ENG-PUDSP21002-R2-PUDSP.pdf Markup Summary

PUD DETAILS

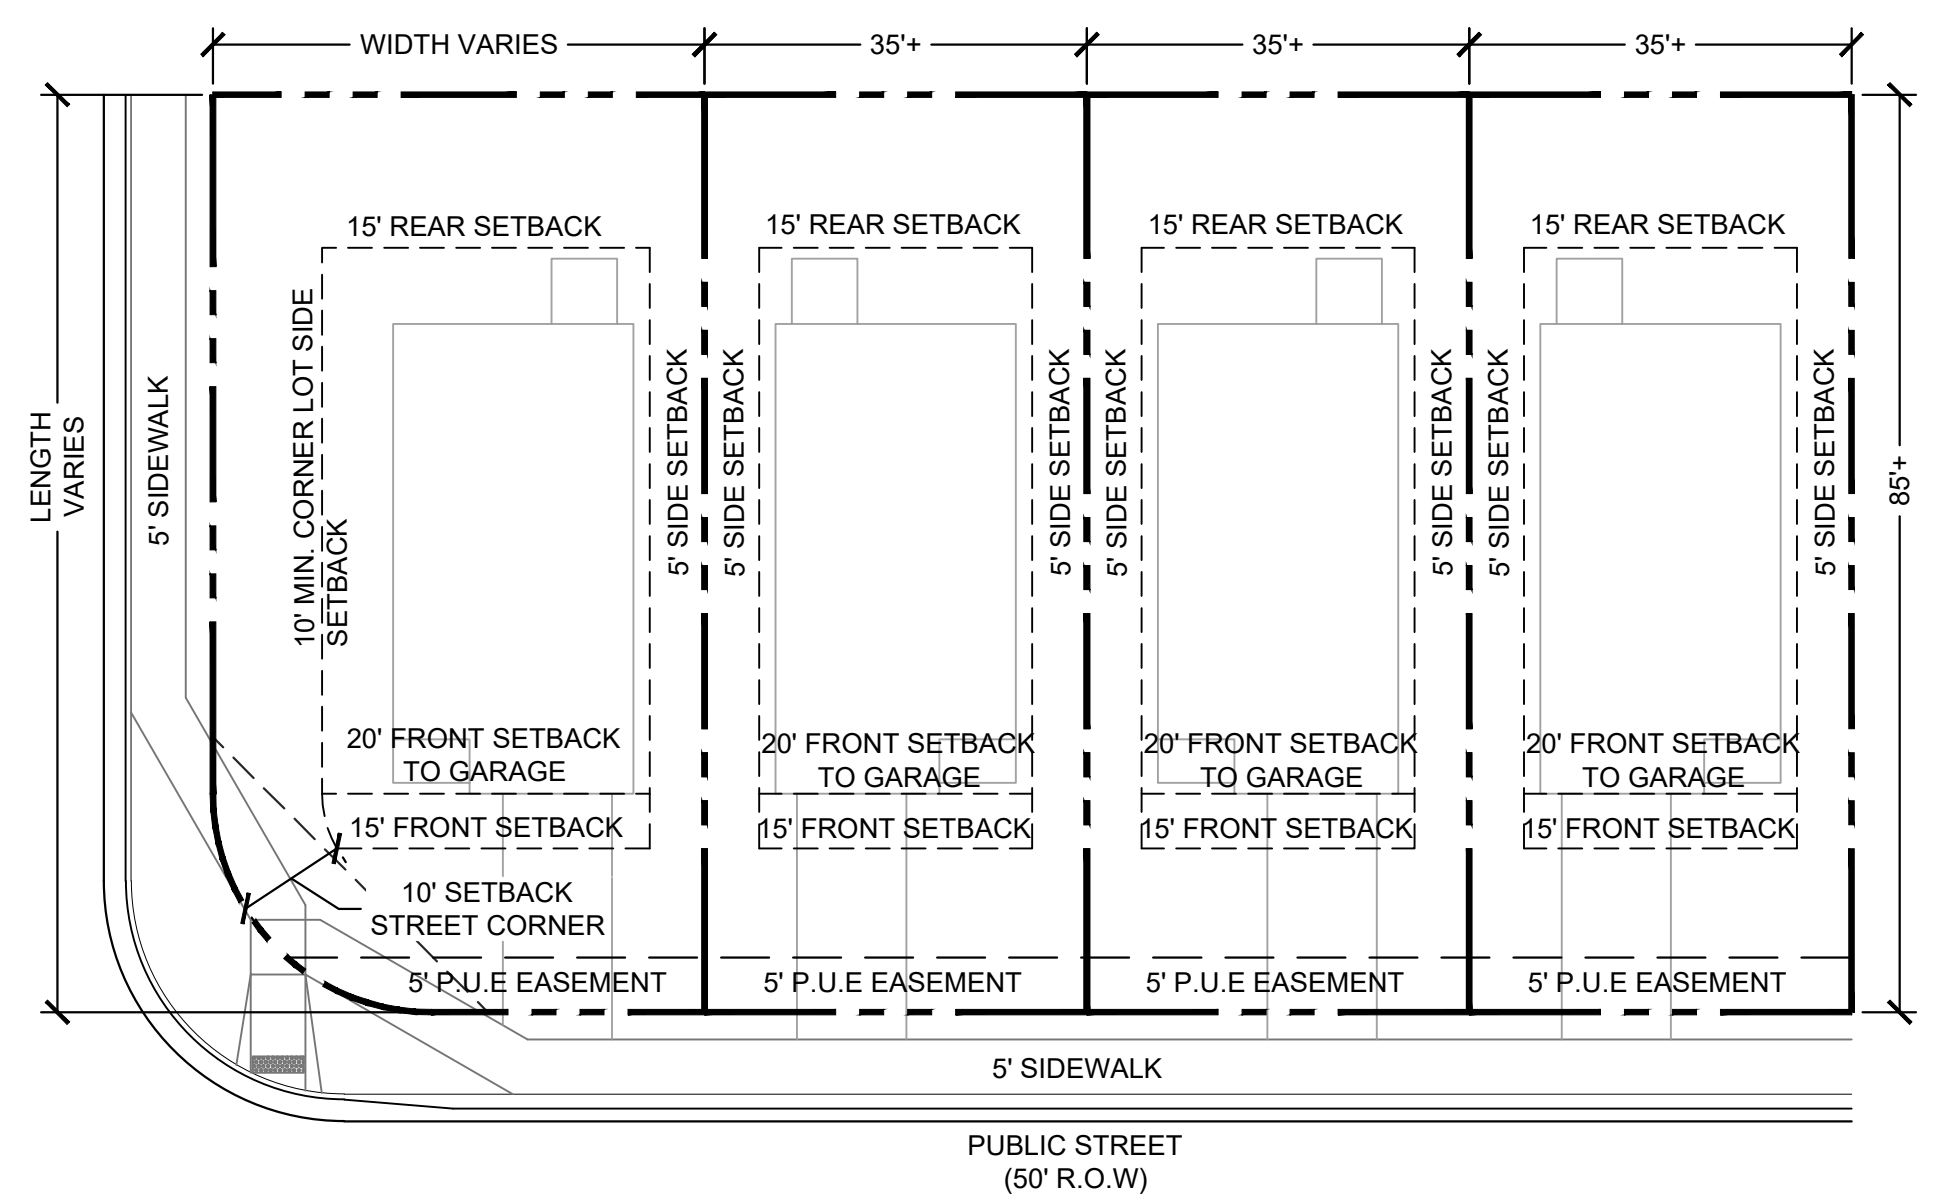
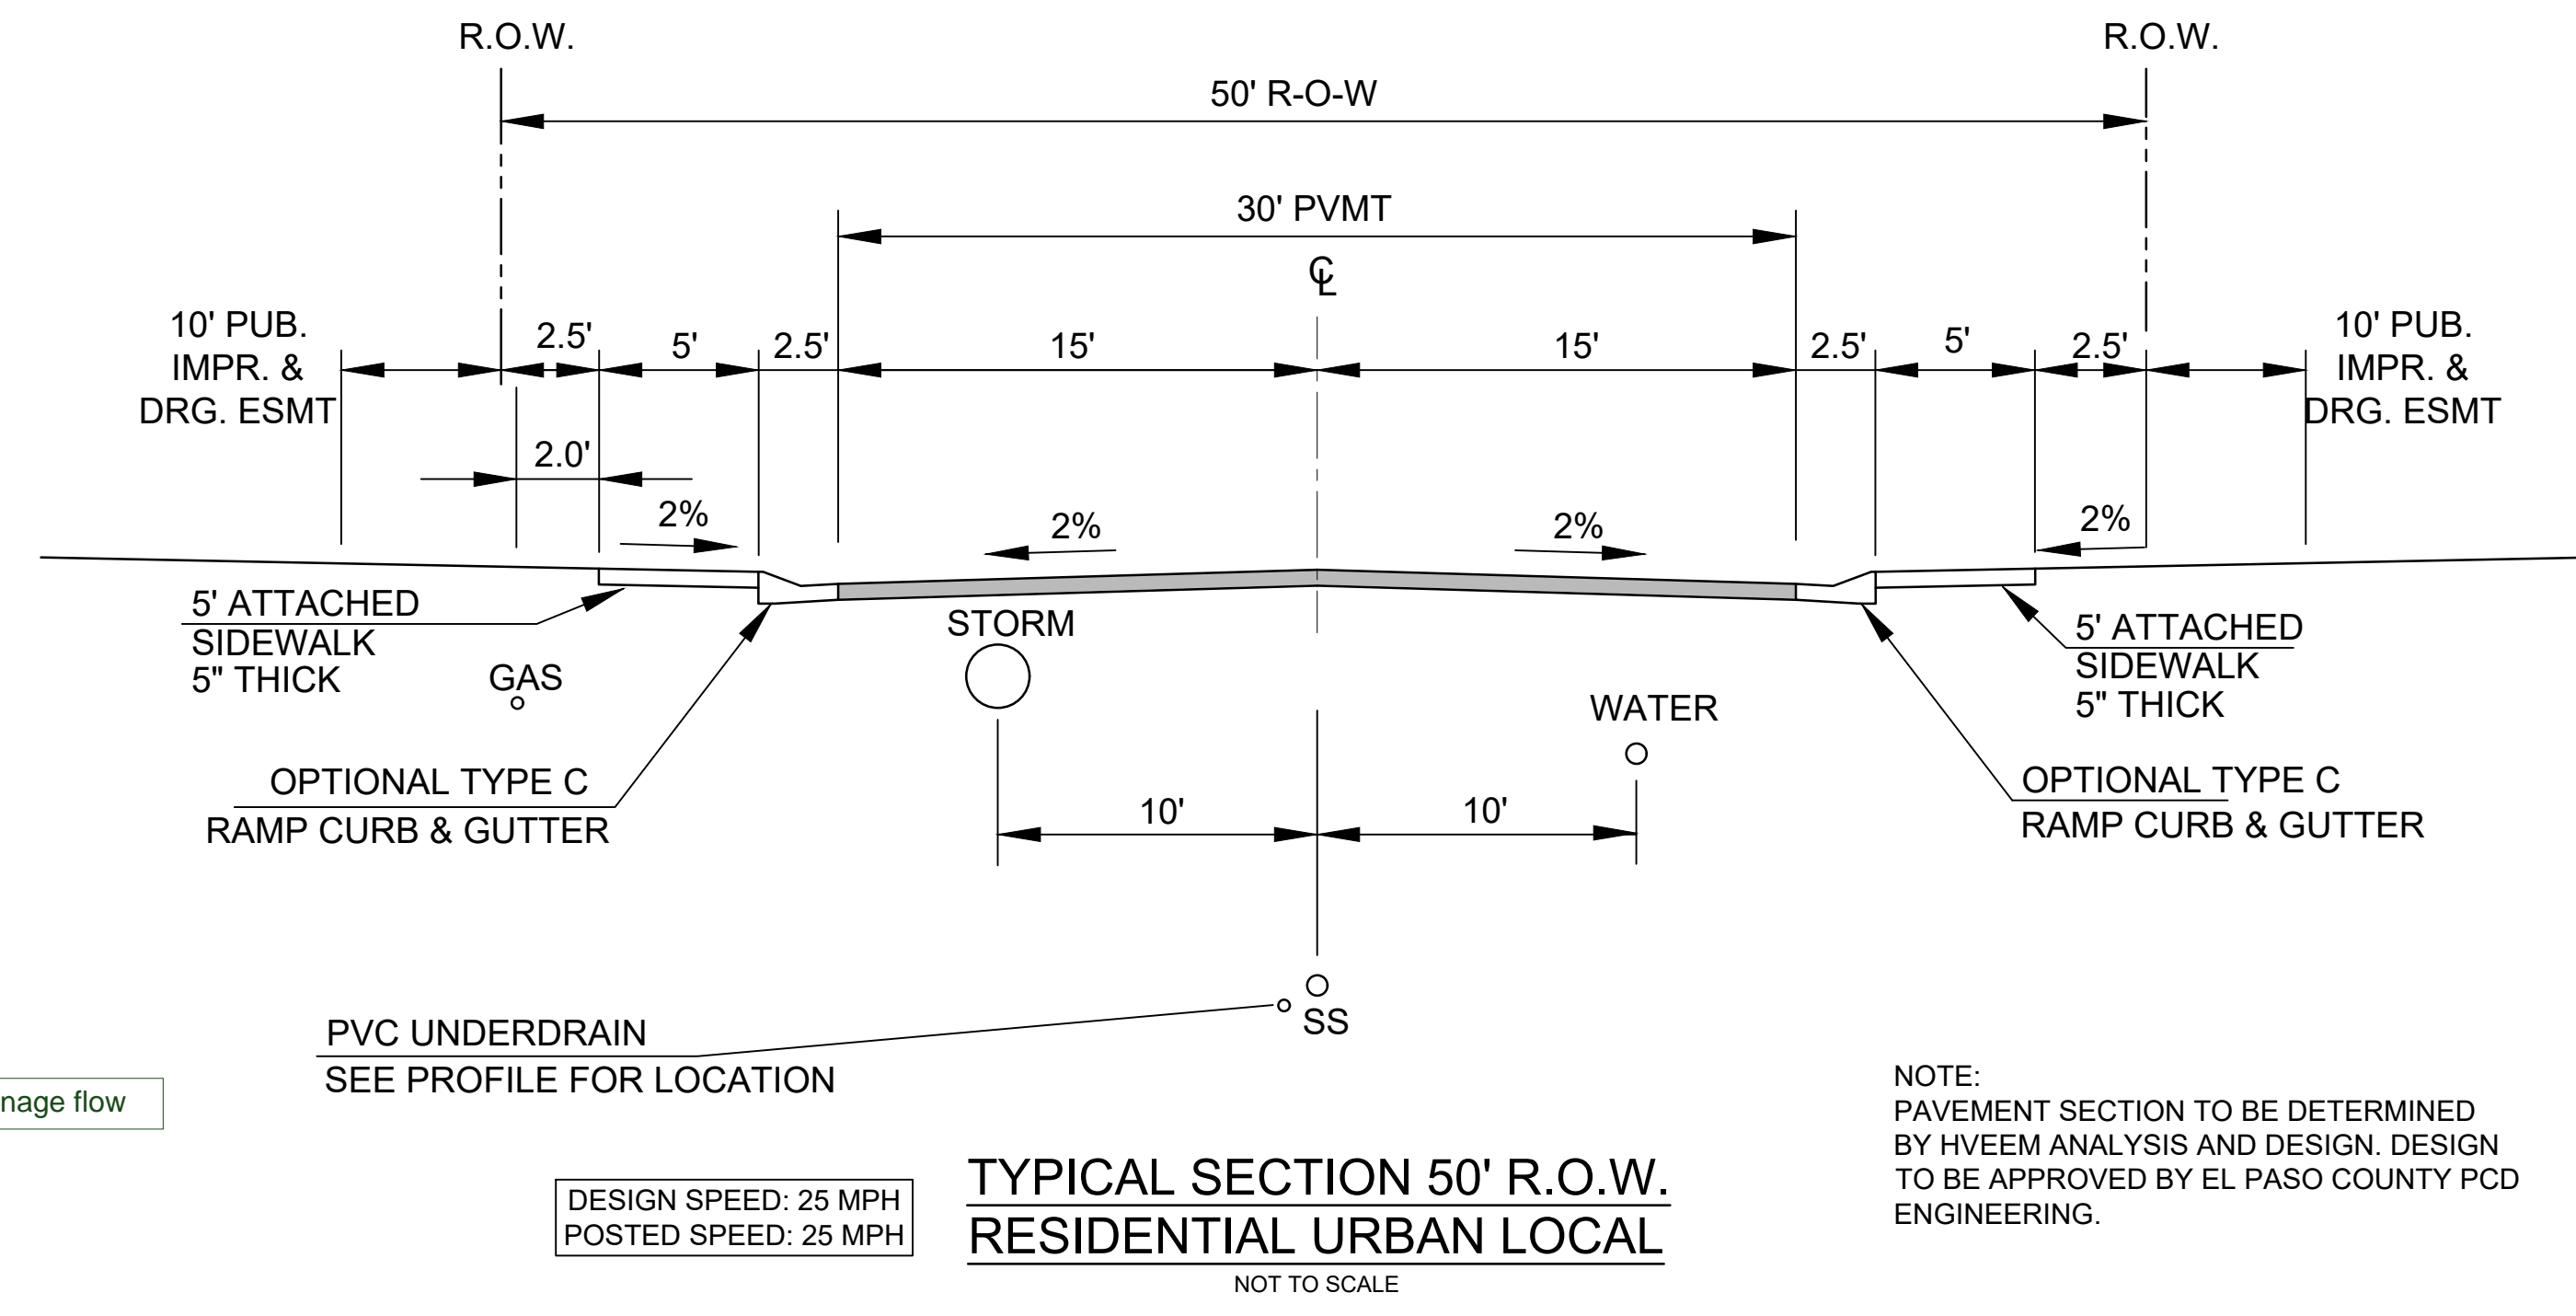
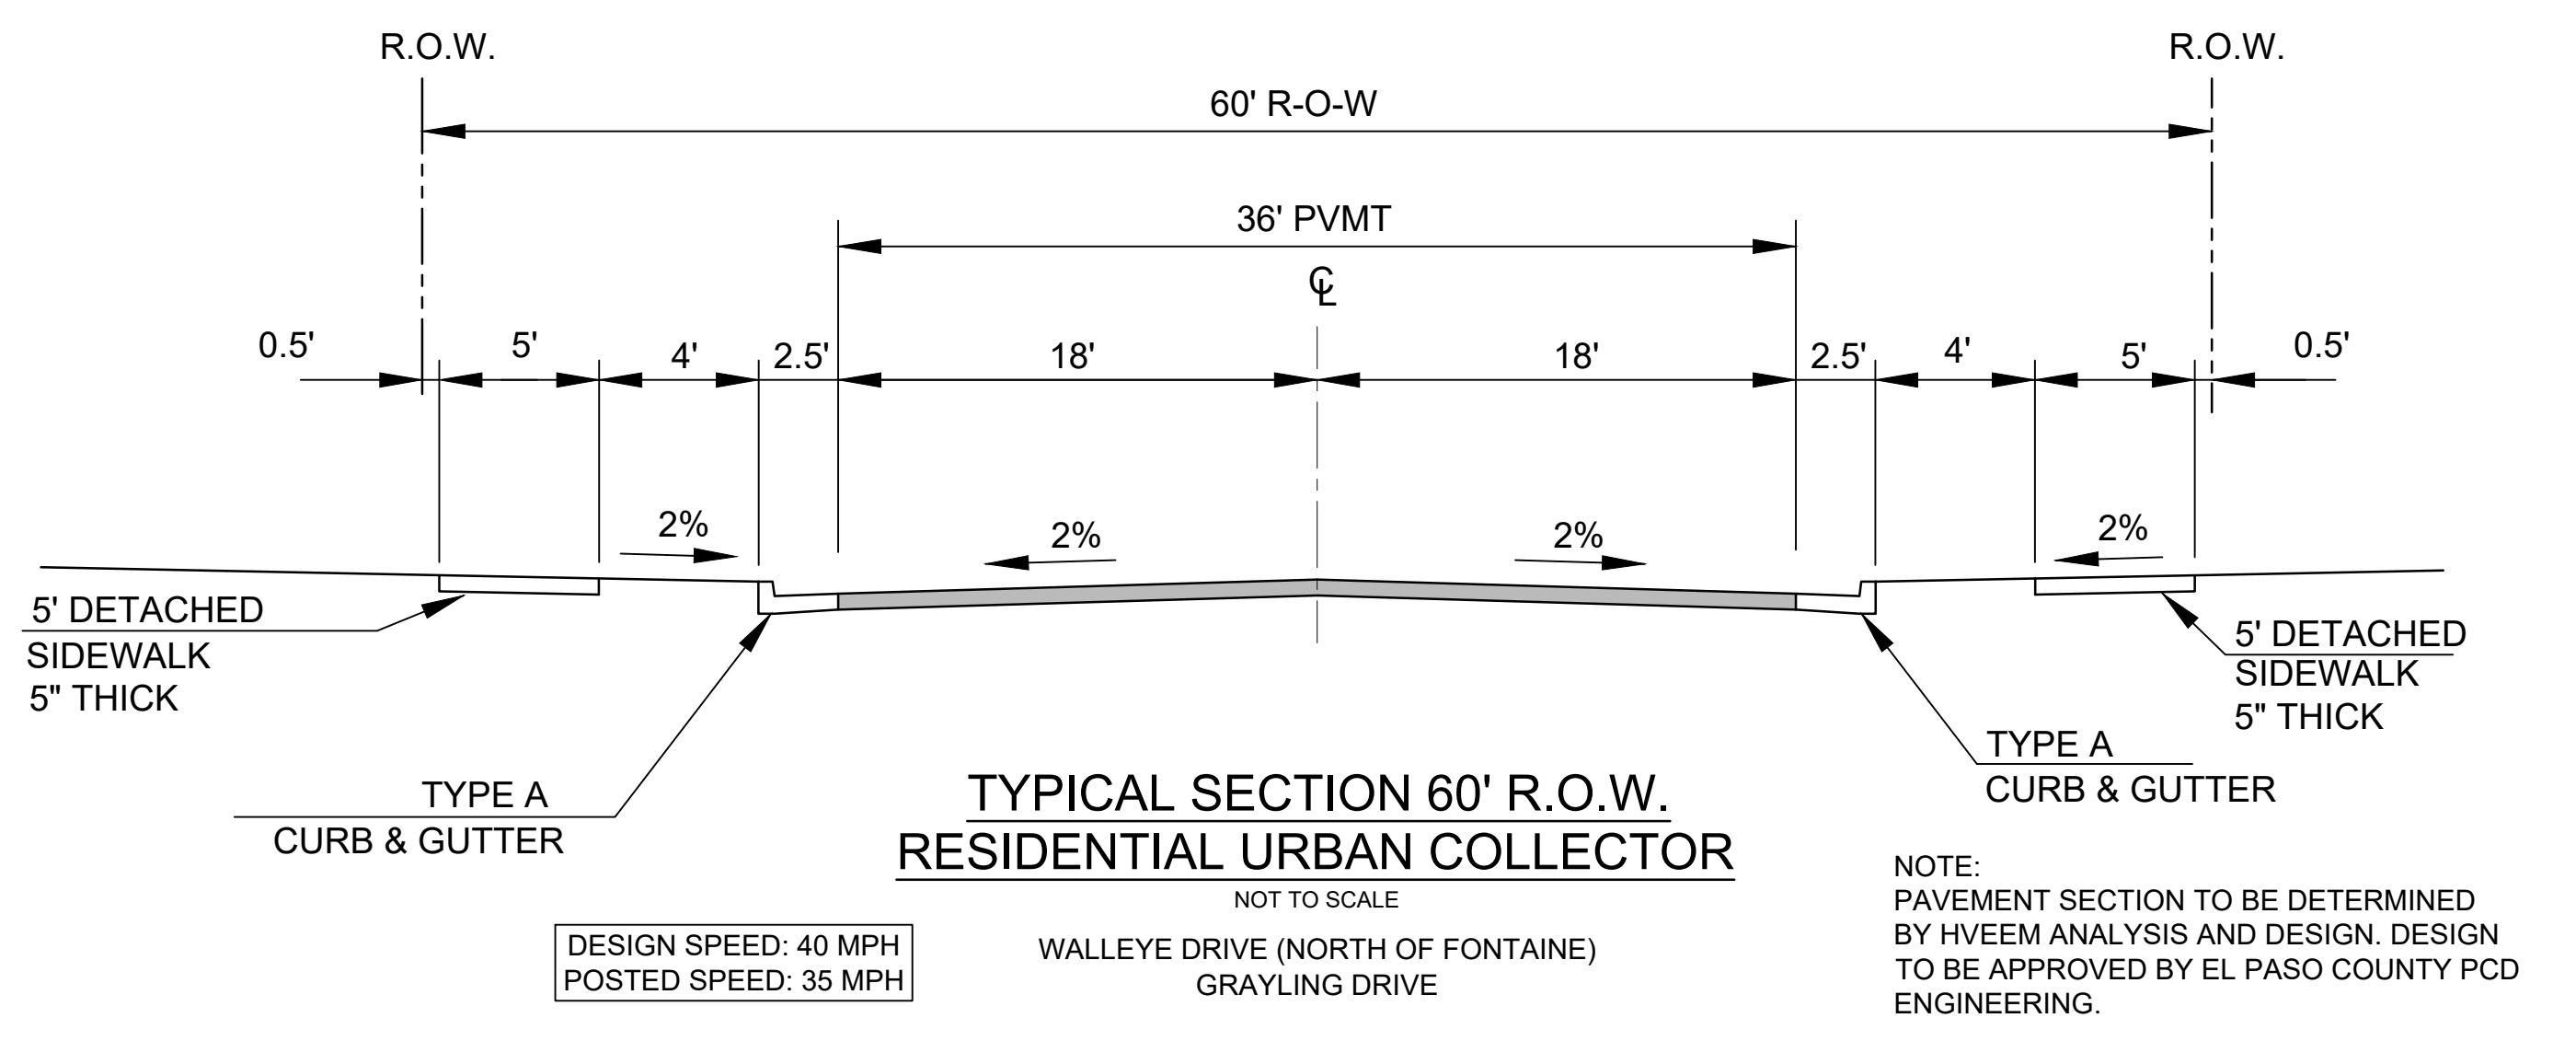
Subject: Callout
Page Index: 2
Date: 7/29/2021 3:47:27 PM
Author: dsdparsons
Color: ■
Layer:
Space:

retaining wall detail

Subject: Callout
Page Index: 3
Date: 7/29/2021 3:51:43 PM
Author: dsdparsons
Color: ■
Layer:
Space:

i dont think you want to say drainage because you have allowances for window wells to project if well is higher and does not impeded flows

Subject: Callout
Page Index: 3
Date: 7/29/2021 3:54:28 PM
Author: dsdparsons
Color: ■
Layer:
Space:

delete this because accessory uses are dependrnt on a specific zone. you have to be specific
